Date: 18th July 2019

Planning Application 3/2019/0446:

Construction of garage with parking for 5 vehicles to be used by Chapel House and Nos 1 and 2 Chapel School, installation of automatic gates, external lighting and CCTV; construction of a garden summer house, greenhouse and patio area. 2 Chapel School, St Nicholas Avenue, Sabden BB7 9HR

SCN1272

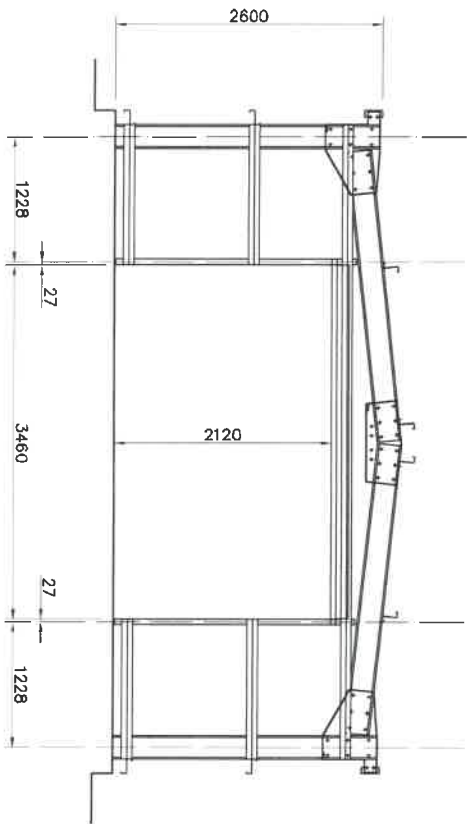
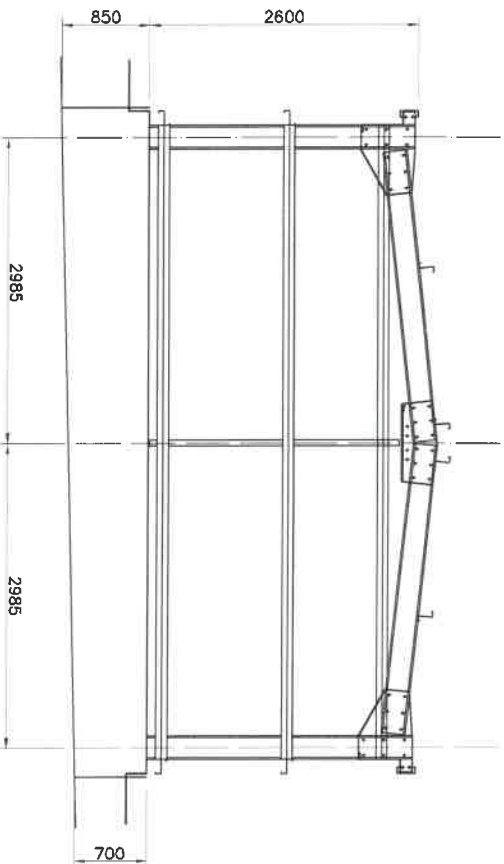
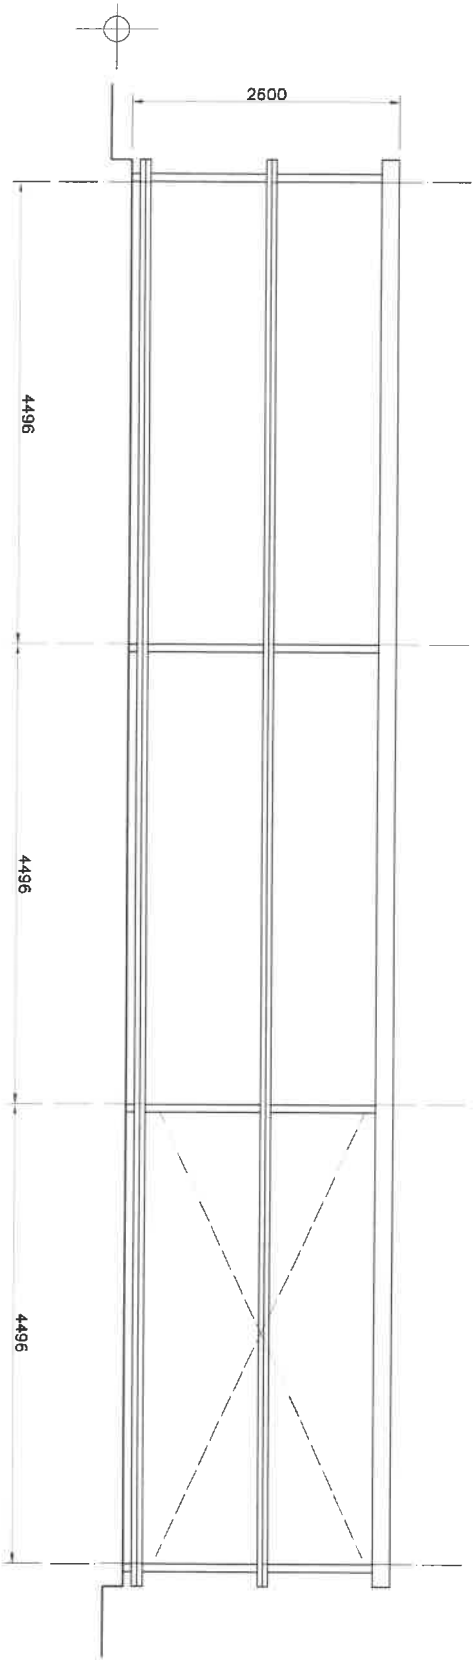
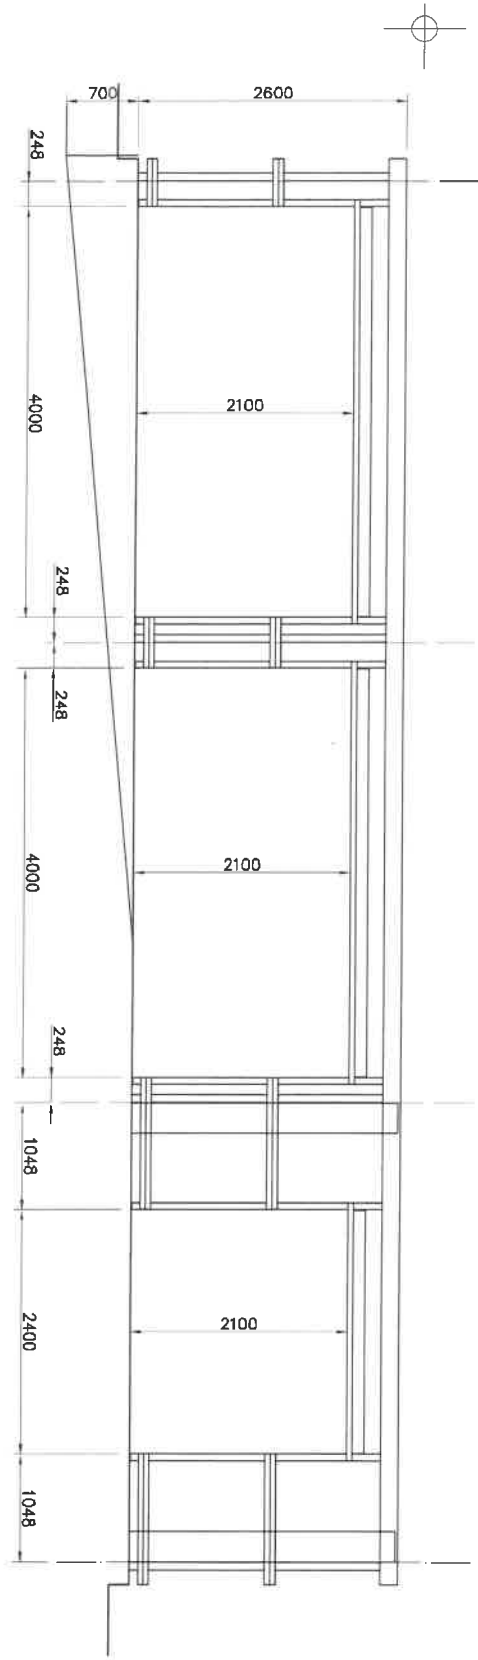
If this confirmation cannot be obtained or is incomplete or inconclusive, then it must be suspected that the groundworks required for the proposed new garage have the

potential to disturb buried remains here. As such a full foundation design with a dimensioned plan and sections minimising this potential should be supplied by the applicants (note the garage base design noted in the heritage statement does not appear to accompany the application documents). It should not be assumed that any human remains will be deeply buried, as it is not unusual for such remains to be disturbed and redeposited at fairly shallow depths as part of normal graveyard activities.

FLOOR PLAN

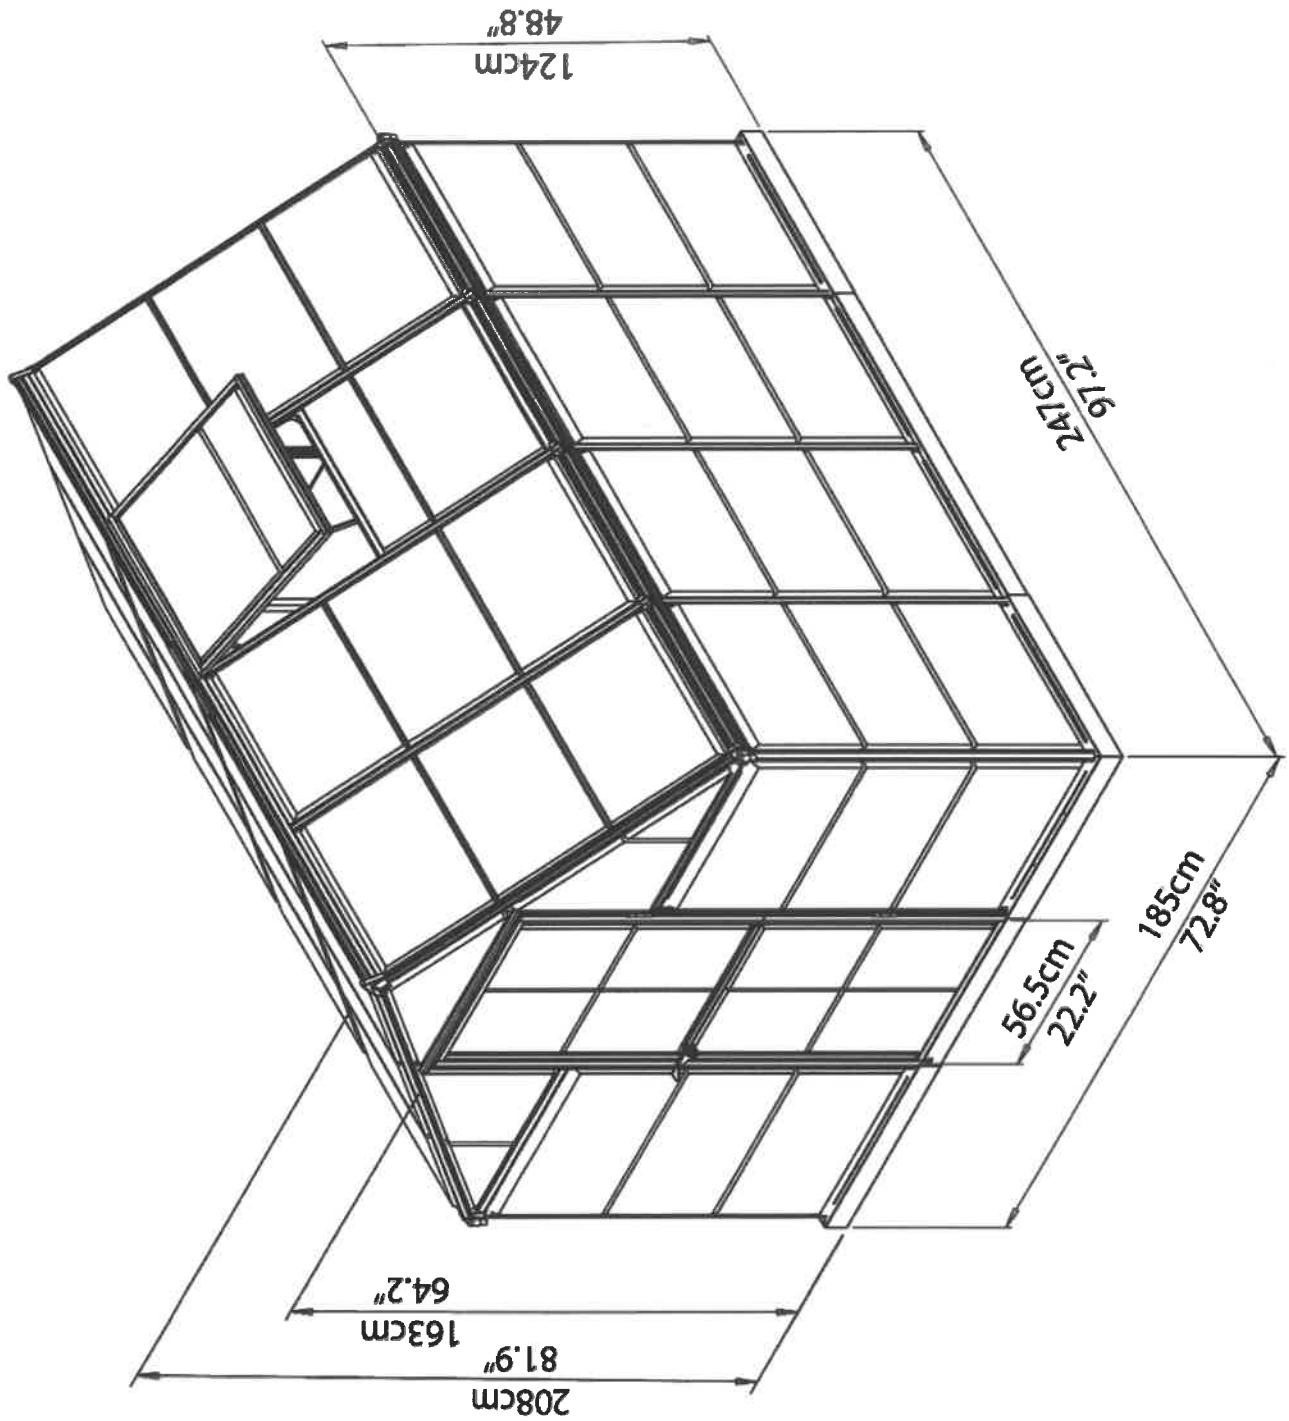
The proposed greenhouse and summer house are likely to stand directly on the ground surface without any foundations and if this can be confirmed then no detailed foundation design would be required for them.

Drawing GL *Proposed*  
**Existing Location Plan ground Level**  
#

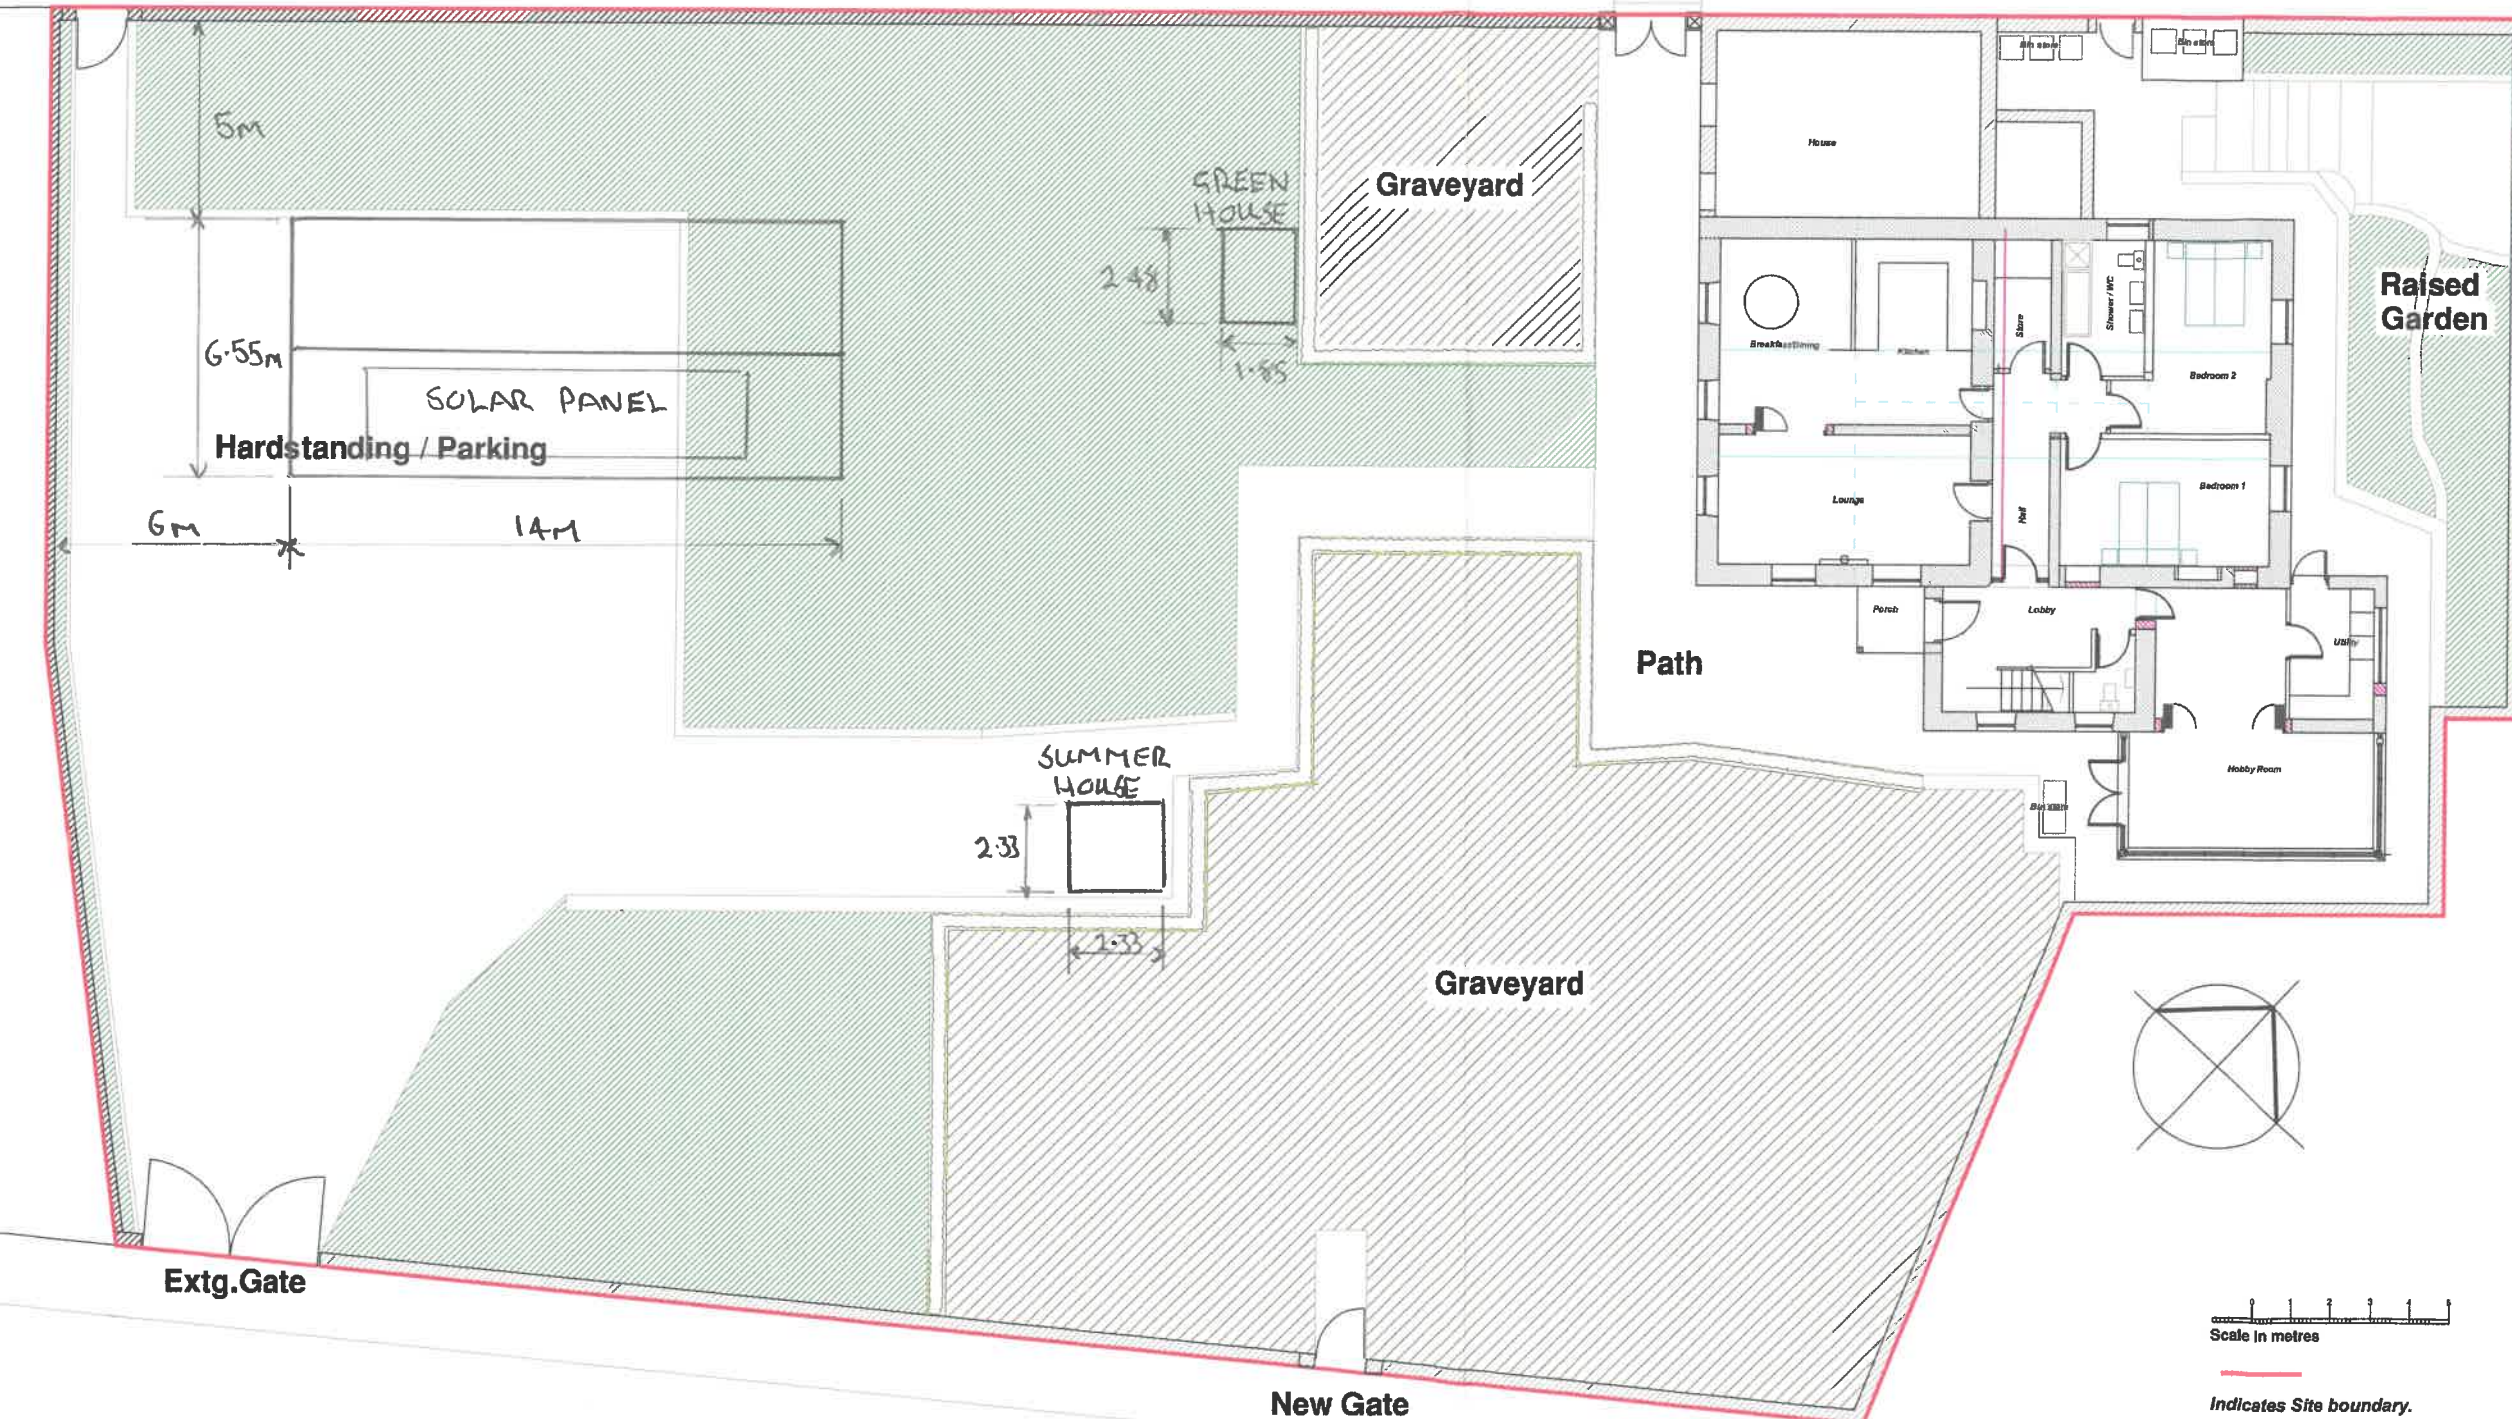
It is notable, however, that the heritage statement and plans state that two areas of the former grounds are 'consecrated as a graveyard', but there is no information showing that burials only occurred in these two areas. The whole of the plot is annotated as 'B.G. (i.e. Burial Ground)' on the OS 1:2,500 map of 1893 (sheet Lancashire 55.08) and as 'Graveyard' on modern OS mapping. There are no obvious limits set to burials within the plot on these or other mapping available to me. Whilst it seems probable that the applicants' mapping is correct, it would seem sensible for the council to request that the applicants confirm in writing that there are no known burials outside of those two areas and, if available, that they back this up with a copy of the burials plan or other appropriate evidence.

The proposed patio area does not appear to be marked on the supplied site plan as proposed, but in the heritage statement it notes that it will be "...*adjacent to the right hand side gable elevation*". It is not obviously stated which building this gable belongs to and to avoid doubt it is recommended that its location and extent are clearly marked on a plan. It may also be appropriate for a detailed foundation design or section drawing to be provided for this construction, if it is like the garage block within an area of potential burials.
